**August 28, 2023**

RE: Crossroads Mixed Use Filing No. 2 Master Sign Plan, **Re-Submittal**

The Crossroads Comprehensive Sign Guidelines document is being re-submitted to address your review comments dated 3/31/2023.

### FREESTANDING MONUMENT SIGN - 2.2A - PLAN

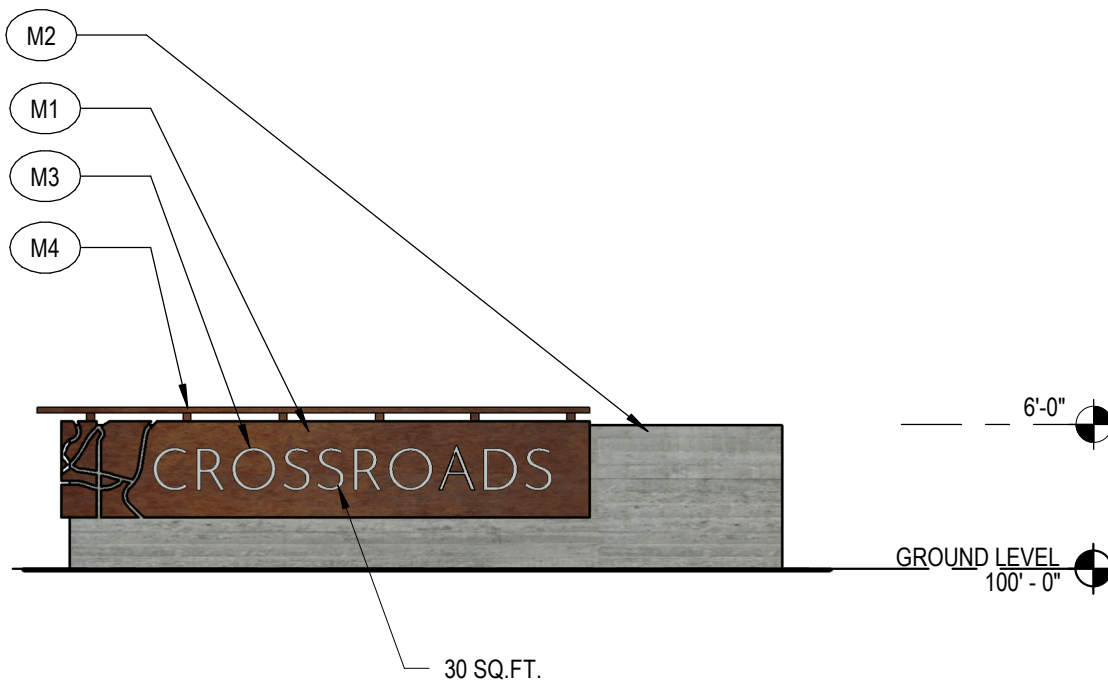
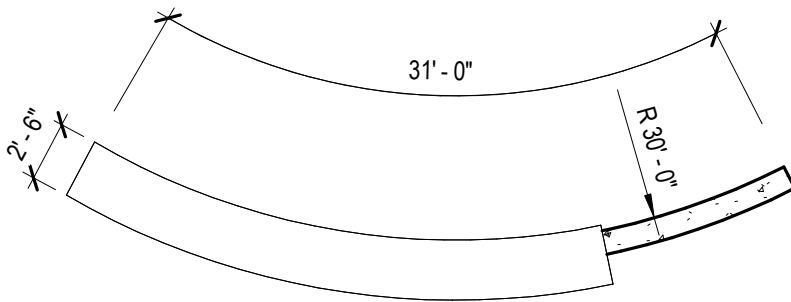
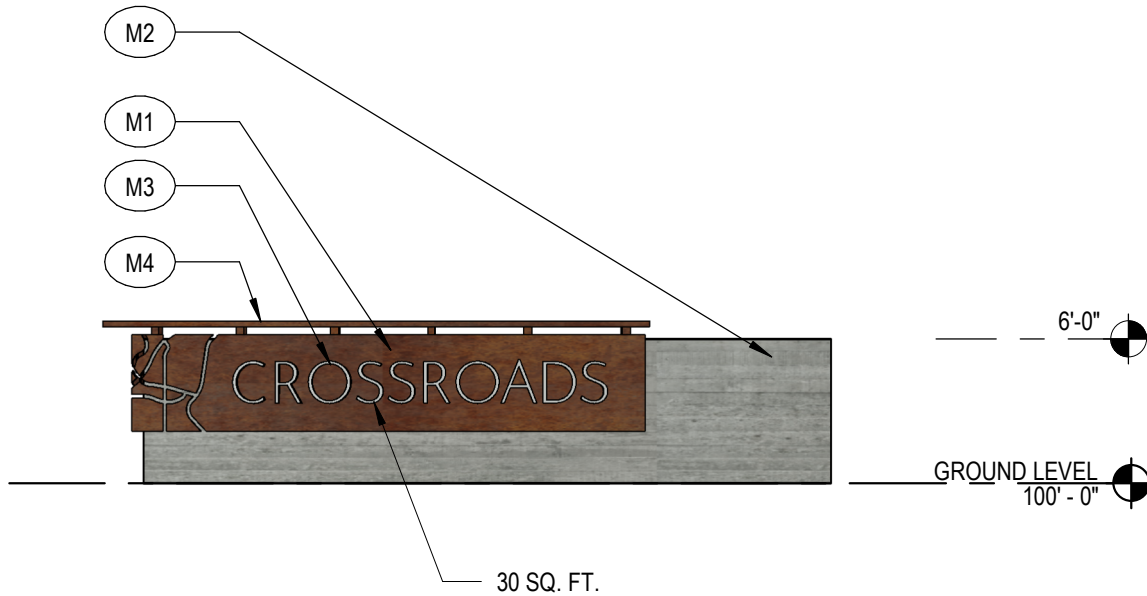
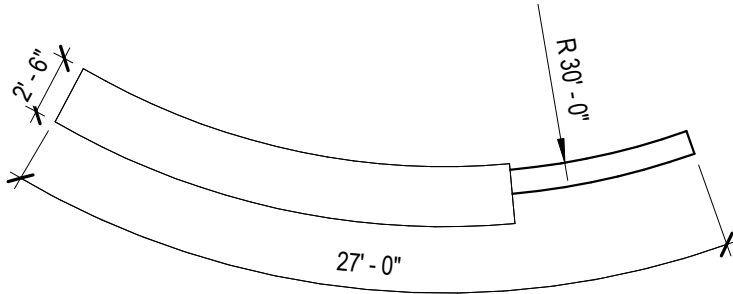
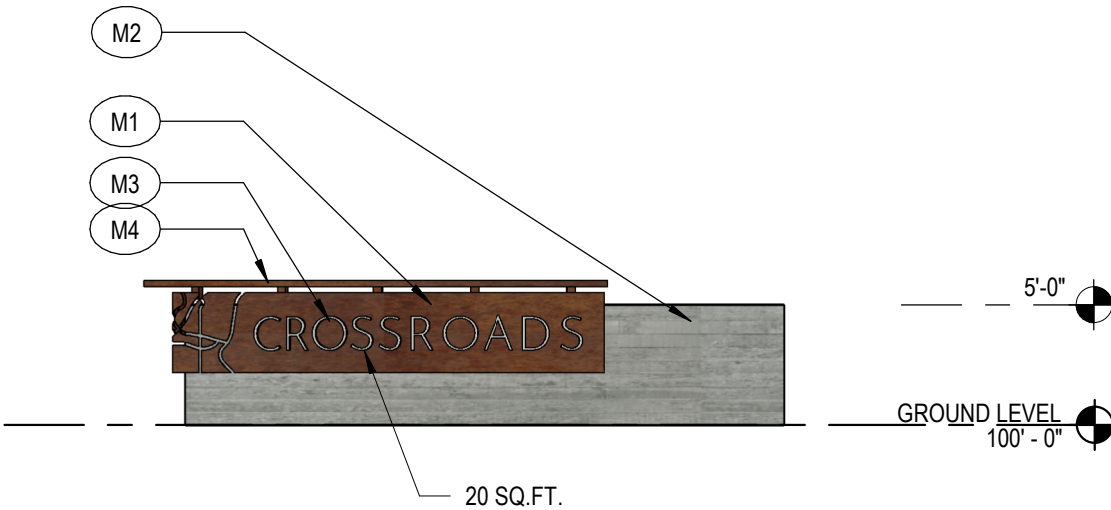
- 6- Note 2.1M was removed calling for signs to be illuminated from below due to development being in a recognized flight path to the Colorado Springs airport.
- 7- Notes 2.2B & C were added to address required signage location and setbacks regarding size of signage and proximity to property lines.
- 11- Note 2.3A4 was added to address required signage location and setbacks regarding size of signage and proximity to property lines.

### FREESTANDING PYLON SIGN - 2.3A - PLAN

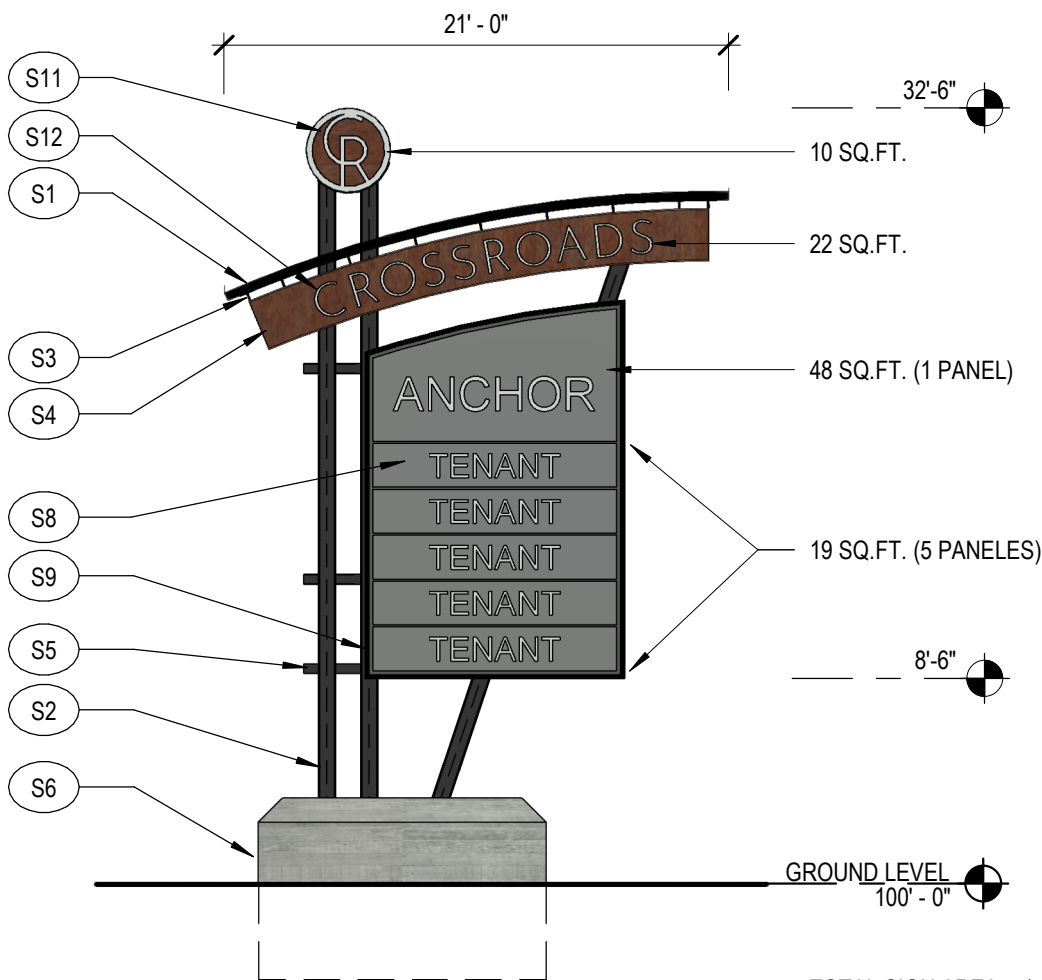
Note 2.3A5 was added to address allowed height of signage in relation to building height.
- 13- Note 2.4A5 was added to address required signage location and setbacks regarding size of signage and proximity to property lines.
